APPLICATION NO. 09AA-1011071011 PROJECT NO. 1003062
 PROJECT NAME SKYVIEW CENTER
 EPC APPLICATION NO.
 APPLICANT / AGENT SCOTT STEFFEN | PHONE NO. 823-1000
 ZONE ATLAS PAGE C-2
 (SDP for SUB), (SDP for BP), (FINAL PLATS), (MASTER DEV PLAN), (IR), (AA)

ONE STOP COMMENT FORM LOG

Re: Modifications to Amended Site Development Plan for Building Permit:
CVS at Indian School and Tramway

Re: Administrative Amendment Request: Proposed CVS at the Northeast Corner of Indian School and Tramway

SITE PLAN

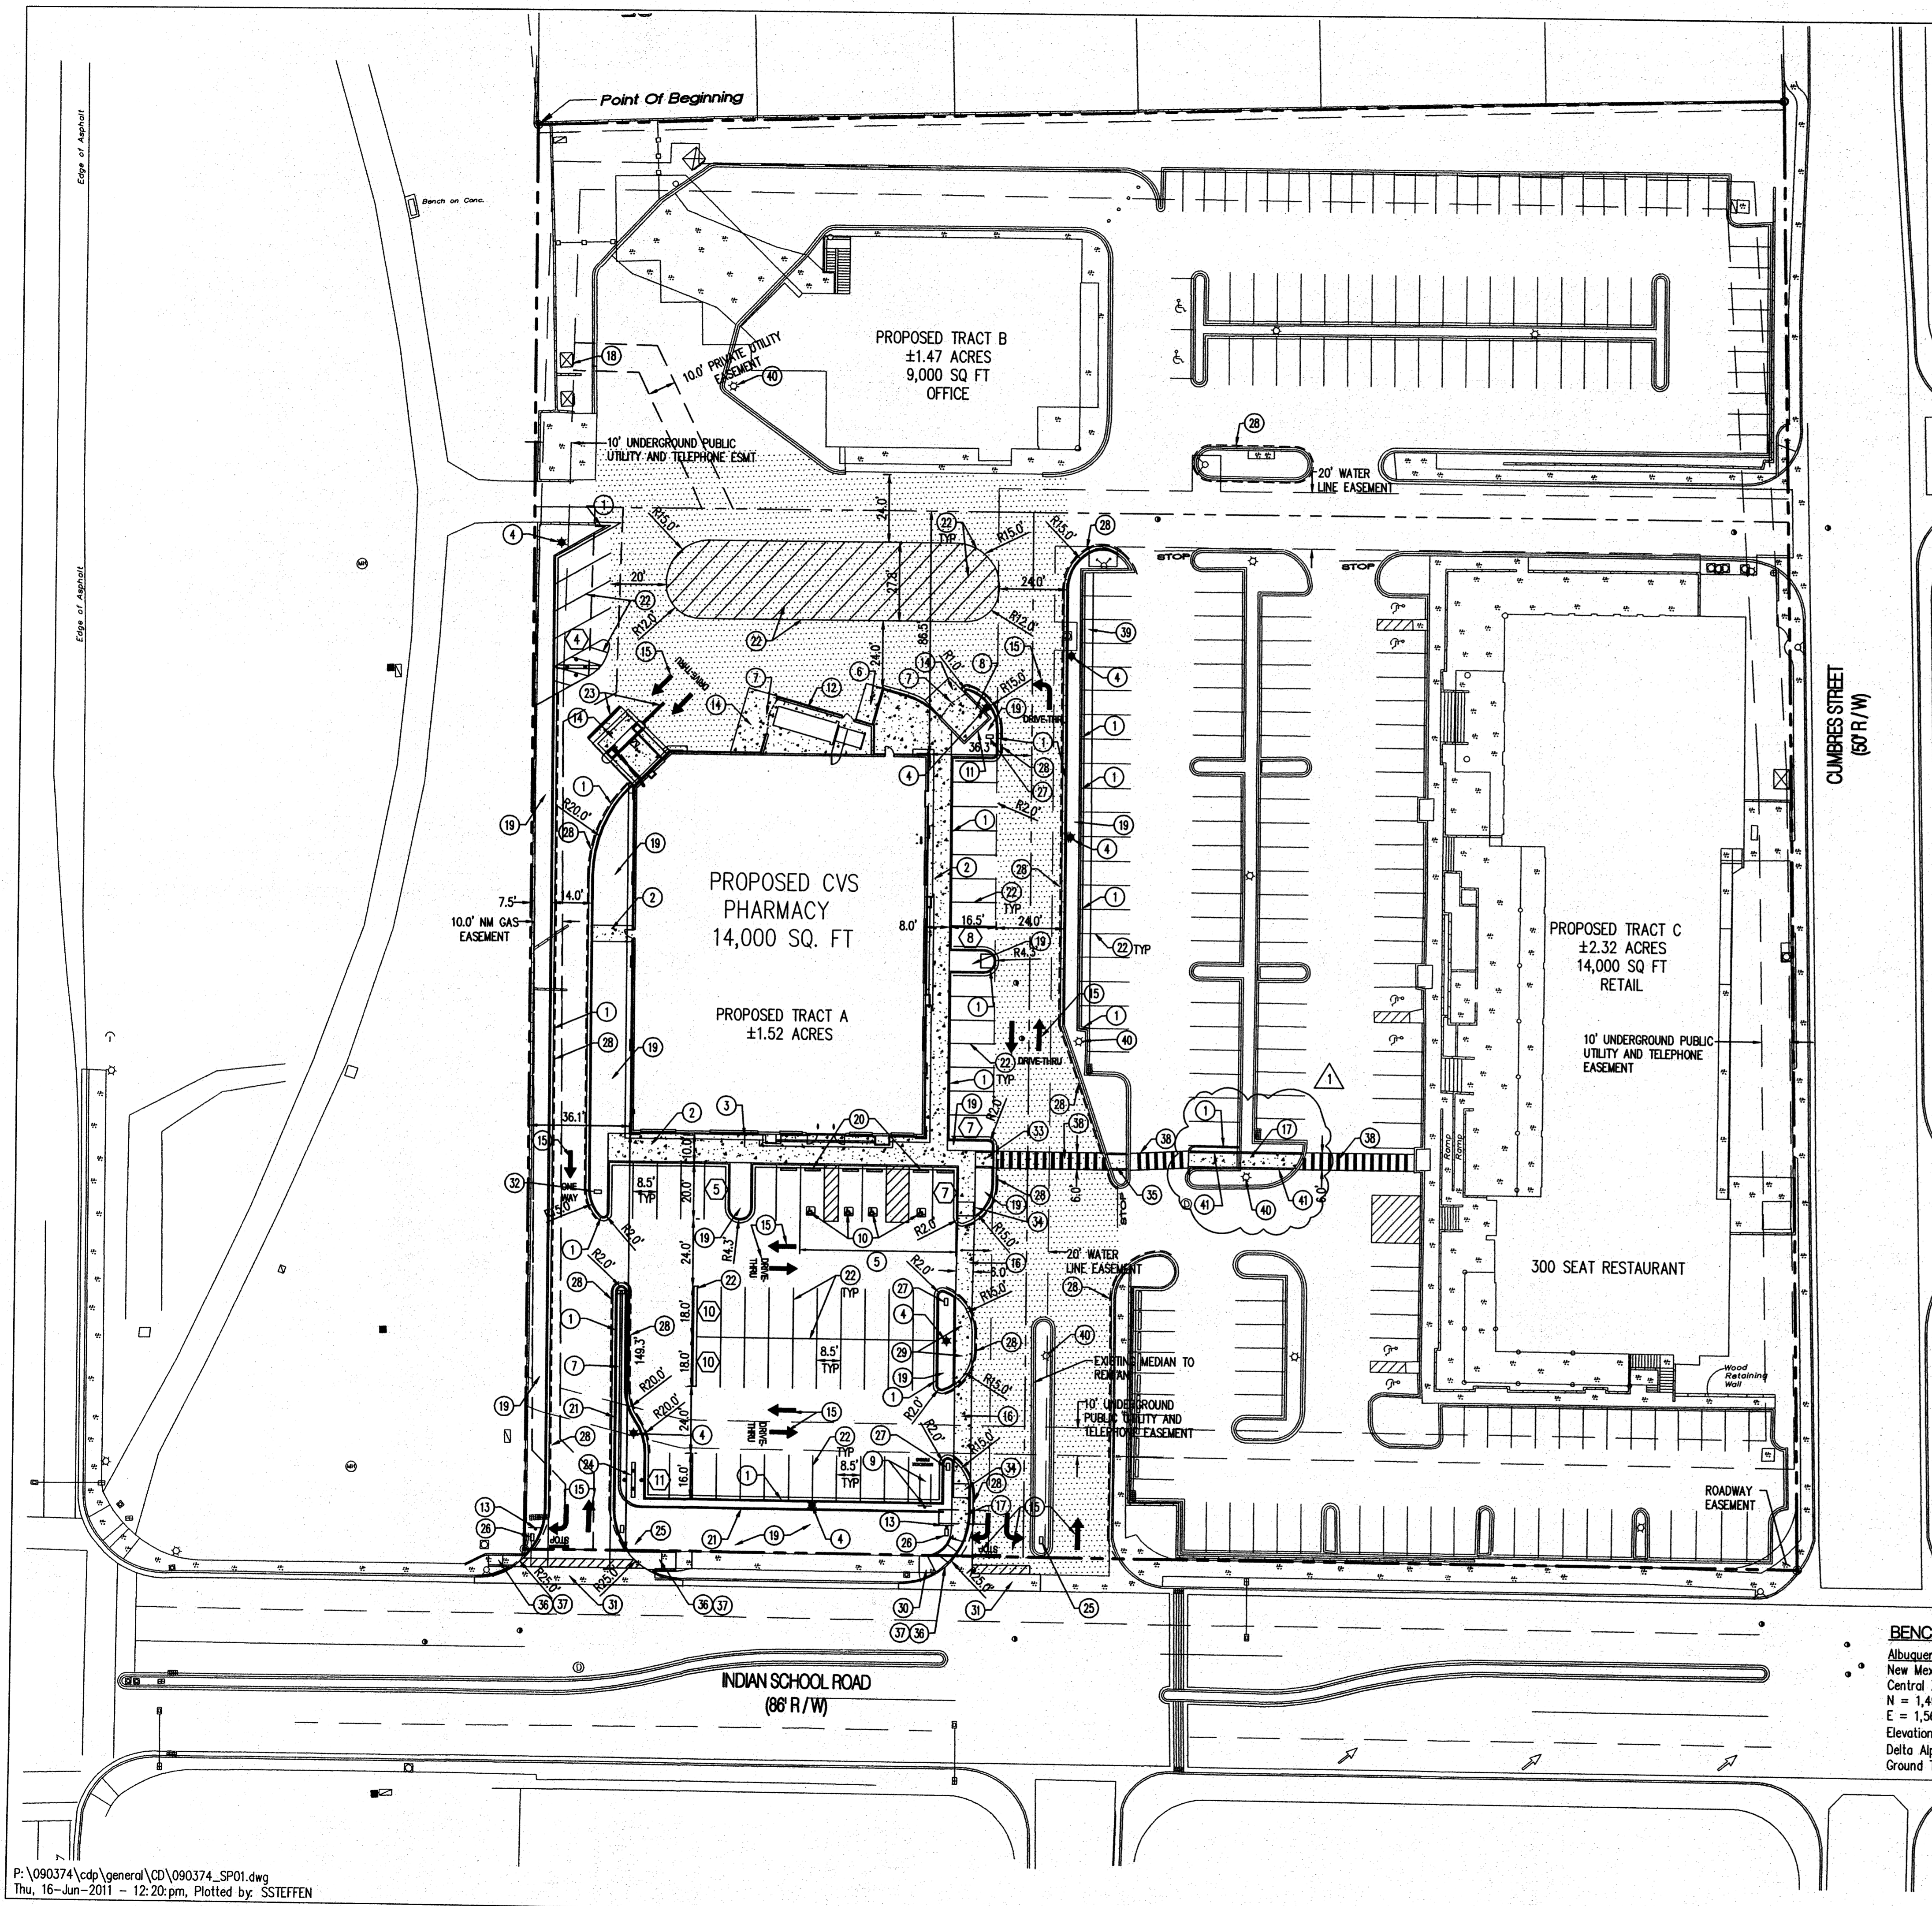
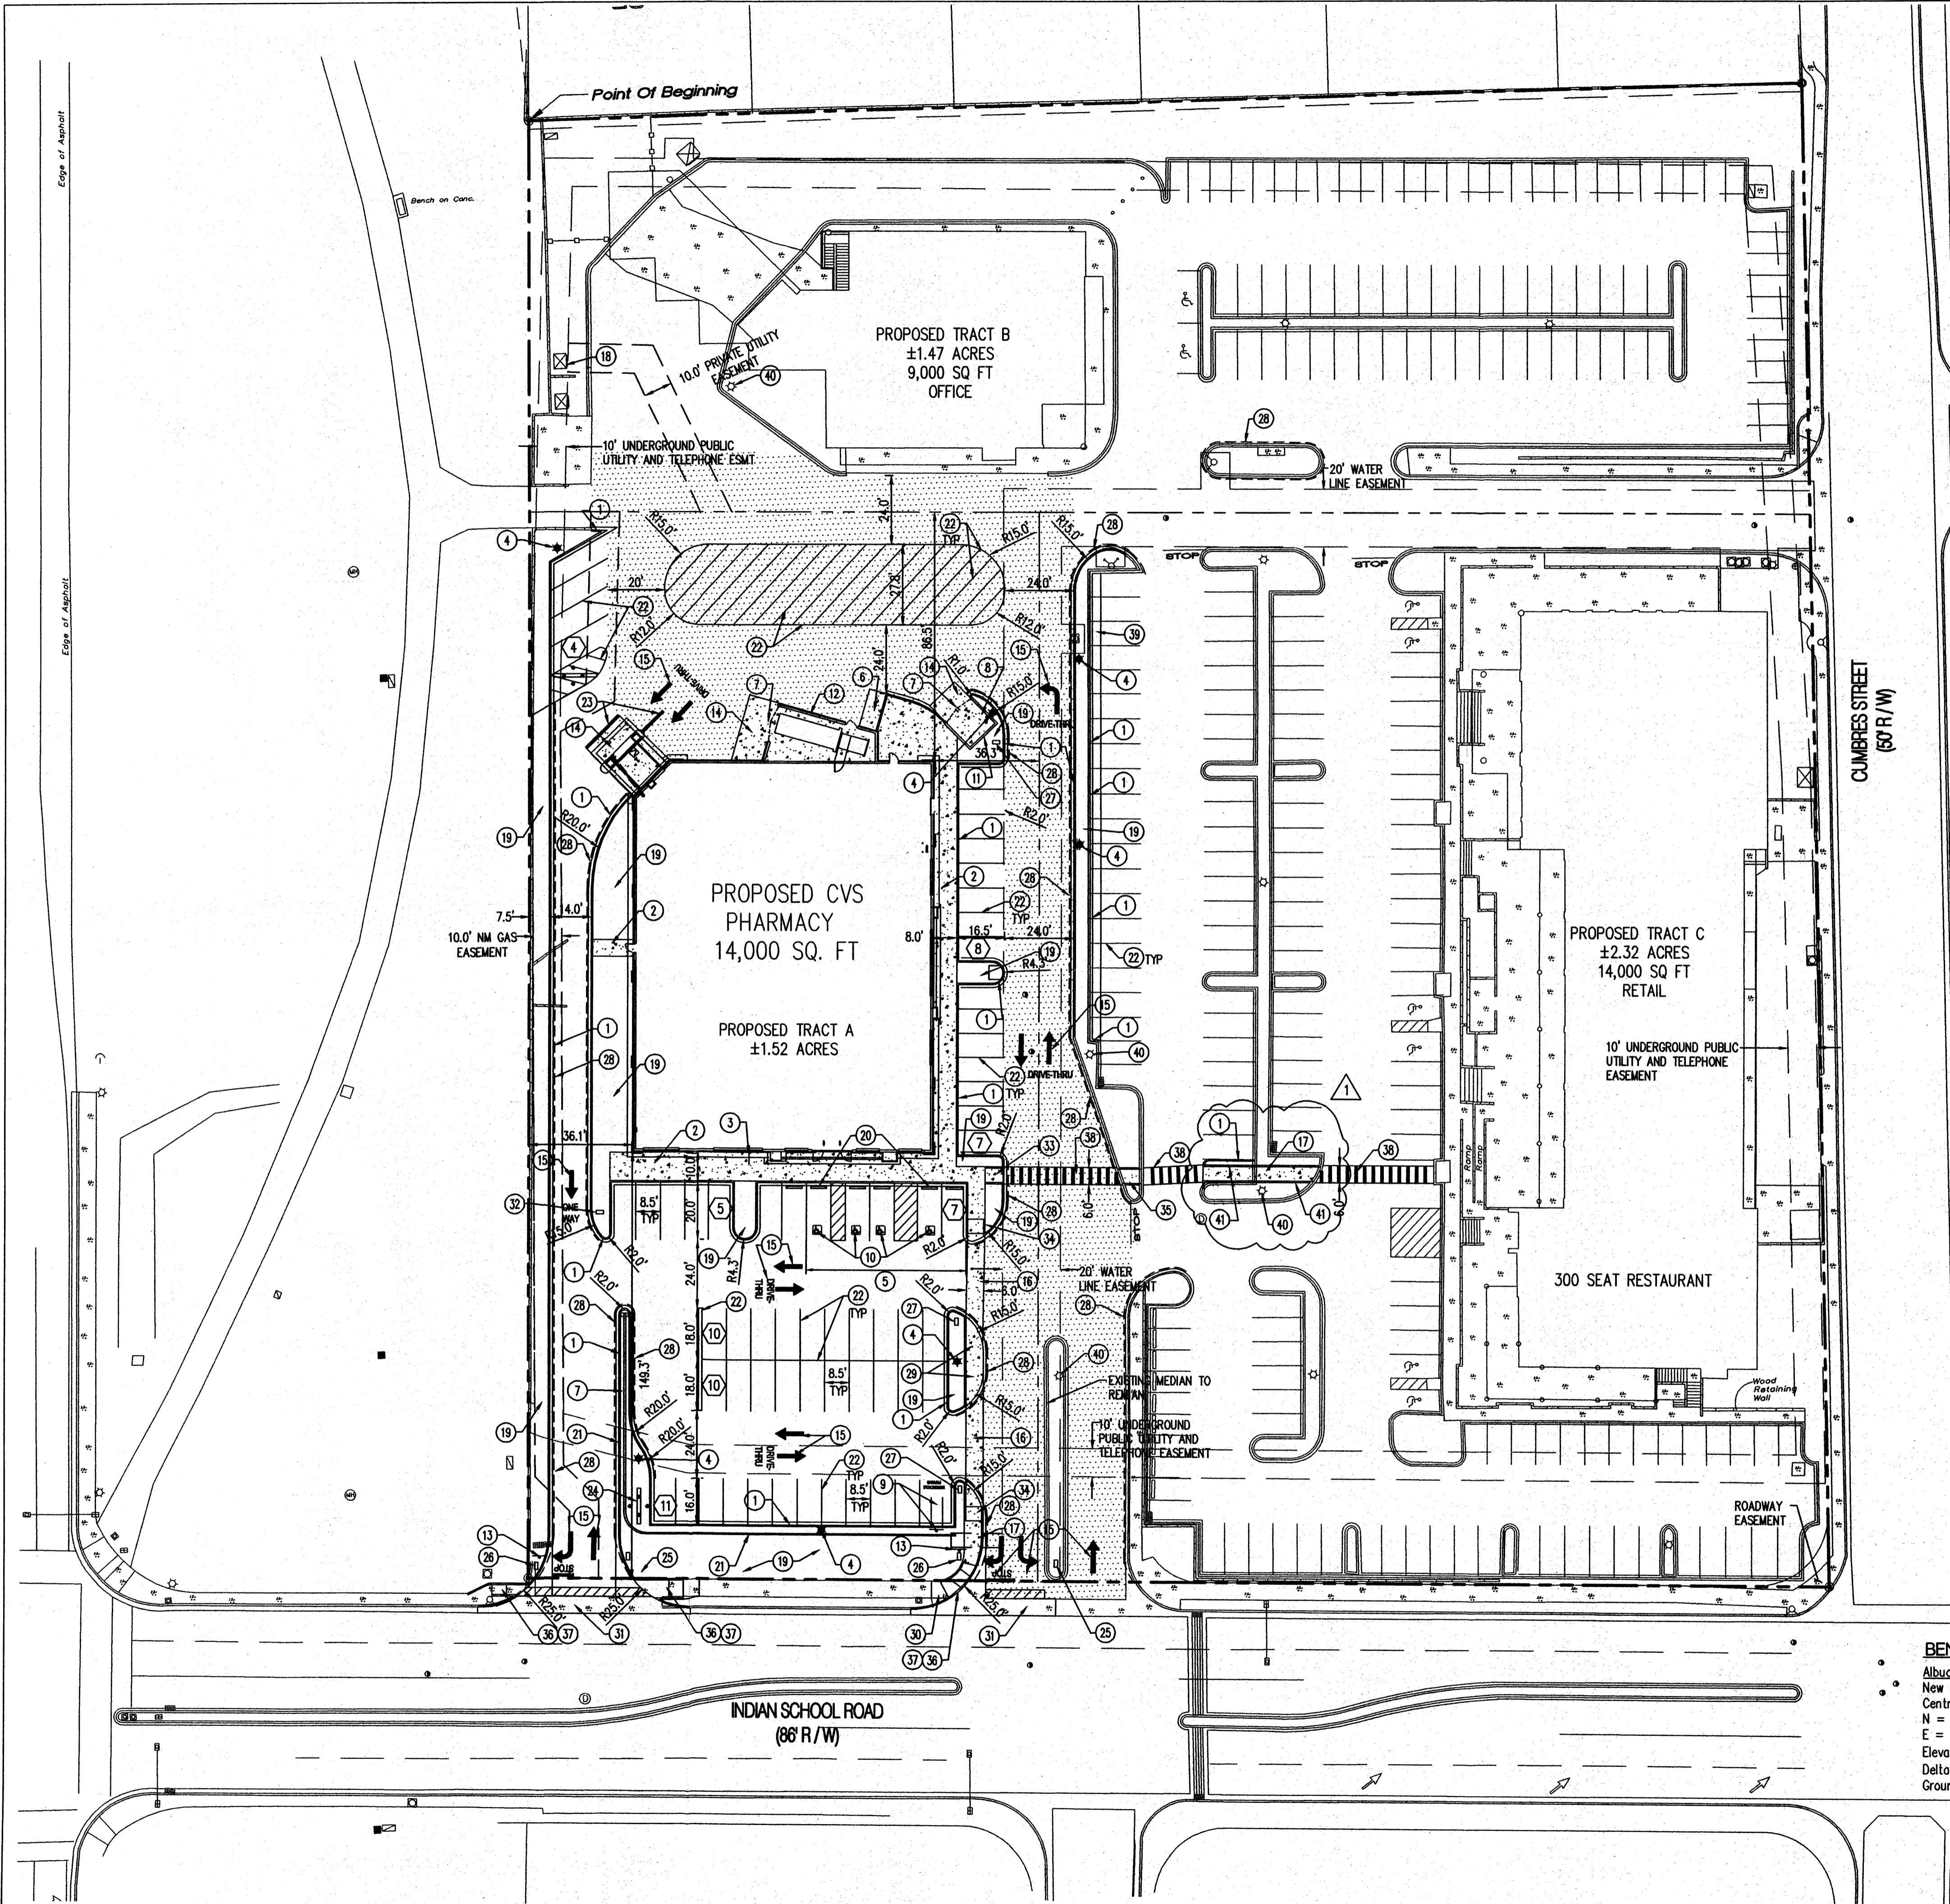
*• why 41 notes?
• should be 26 notes
based on Sept. 09 approval
• submitted wrong reference -
(11-09 AA pertains to
replat, not SPBP)*

Per our discussion on Friday, June 3rd, 2011, the purpose of this letter is to describe the reason for eliminating two ramps proposed to be built within the new pedestrian connection linking the subject CVS Pharmacy to the existing shopping center east of it. As we discussed, this pedestrian connection was required to be added as a condition of the Administrative Amendment approval dated November 3, 2009.

With the above information as a background, the Administrative Amendment drawings approved in November of 2009 indicate that 2 ramps (keyed note 19) would be built along the pedestrian connection route in a parking end aisle landscape median (see attached). These ramps are not necessary and this request is to eliminate them and construct the walkway flush with the drive aisle surface through the median. This will result in a better pedestrian walking experience as they won't be forced to maneuver up a steep ramp and then down again approximately 40' away. The enclosed drawings indicate this modification.
